DRAWN BY: O.E. WATTS DATE: 1-20-20 DWG. NO.: 19-5348-05 SURVEYED BY: DEW, ESW, 6-26-19	APPROVED BY: PROJ. NO.: DWG.:	REVISIONS 7-28-20 REVISED PER COUNTY REVIEW COMMENTS DEW	OLIVER E. WATTS CONSULTING ENGINEER COLORADO SPRINGS	PROJECT 10634 & 10658 MALTESE POINT LOTS 2 & 3, ROLLING THUNDER BUSINESS PARK EL PASO COUNTY	SHEET NAME GRADING AND EROSION CONTROL PLAN	SHEET NO. 1 OF 2
---	-------------------------------------	--	--	---	---	---------------------

DRAWN BY: O.E. WATTS DATE: 1-20-20 DWG. NO.: 19-5348-06 SURVEYED BY: DEW, ESW, 6-26-19	APPROVED BY:	REVISIONS 7-28-20 REVISED PER COUNTY REVIEW COMMENTS DEW	PROJECT 10634 & 10658 MALTESE POINT LOTS 2 & 3, ROLLING THUNDER BUSINESS PARK EL PASO COUNTY	SHT. NAME EROSION CONTROL PLAN	SHT. NO. 2 OF 2
	PROJ. NO.				
	DWG.

GEC Plan_v2_redlines.pdf Markup Summary

DRAWN BY: O.E. WATTS

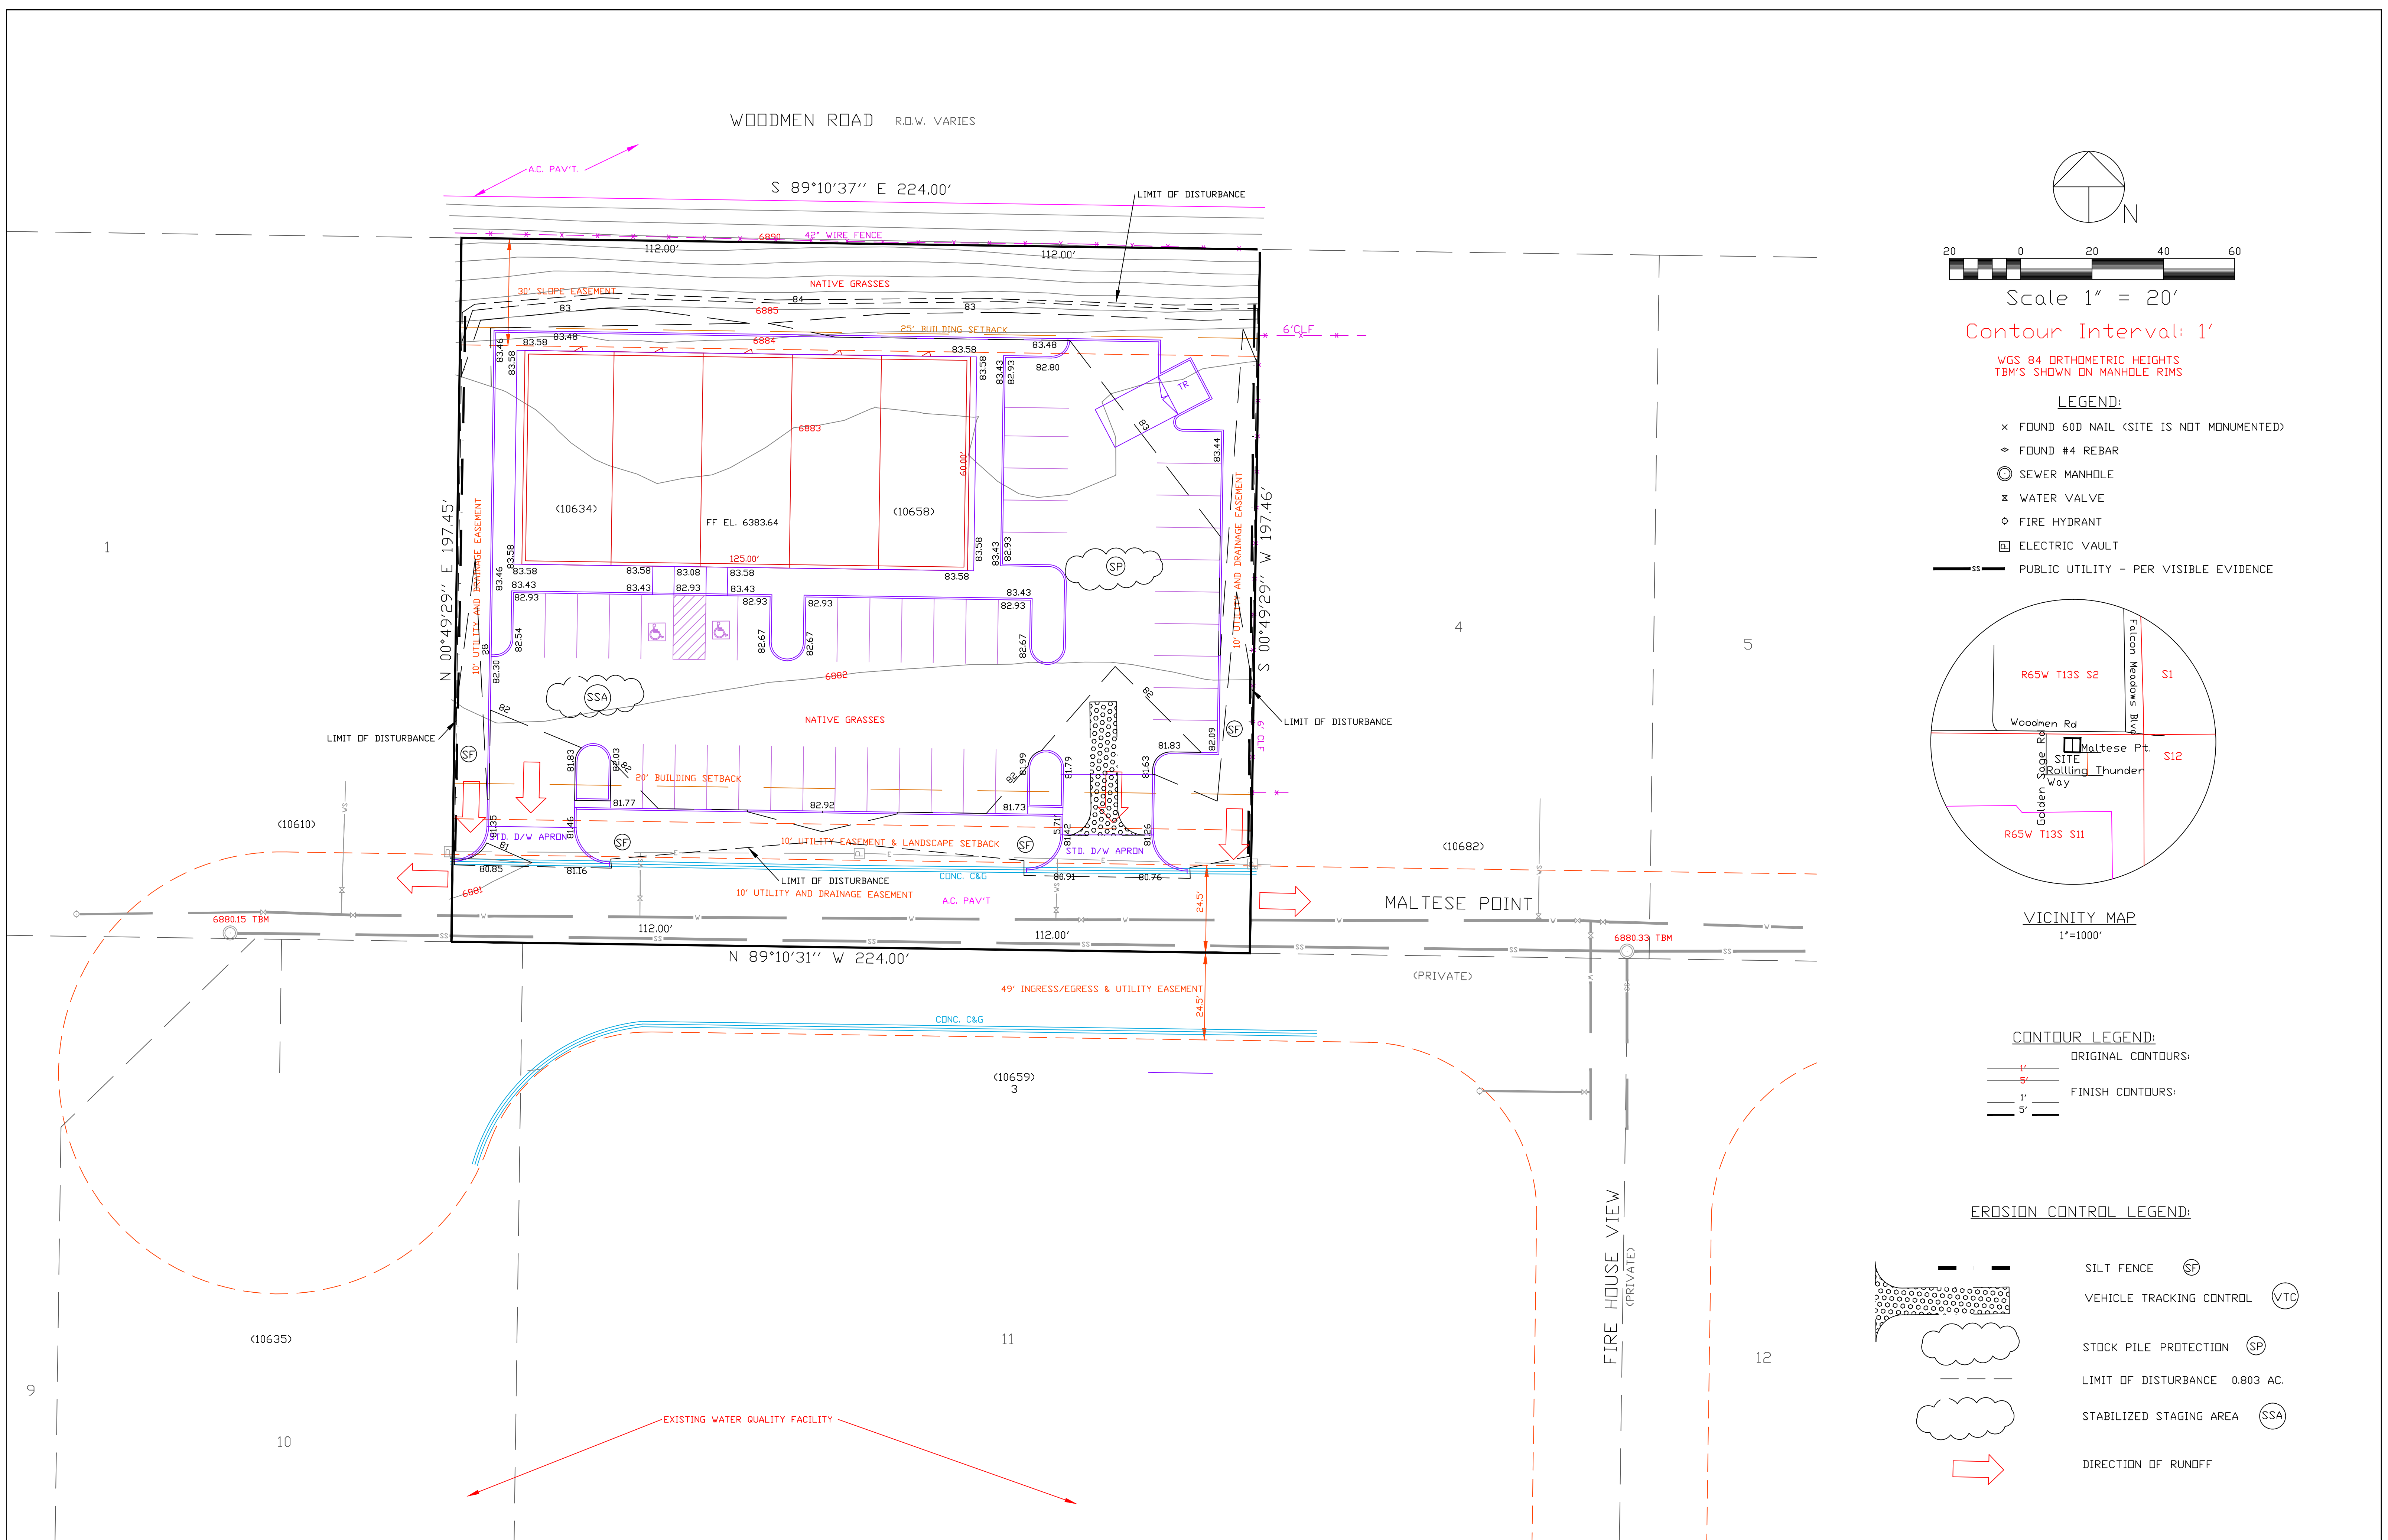
Review 1 comment: Please label the proposed curb and gutter throughout the site and provide a detail.

Review 1 comment: Provide a driveway detail

Review 1 comment: Please add a leader to indicate the location of this easement.

Review 1 comment: Please show the existing contours along Maltese Point

? The site plan indicates the parking areas/drive aisles as Asphalt. Please revise.

it appears that these may be curb openings to allow runoff to exit this parking area. Please label them and indicate the size.

Review 1 comment:
Add PCD File No. PPR2010
Review 2: Unresolved
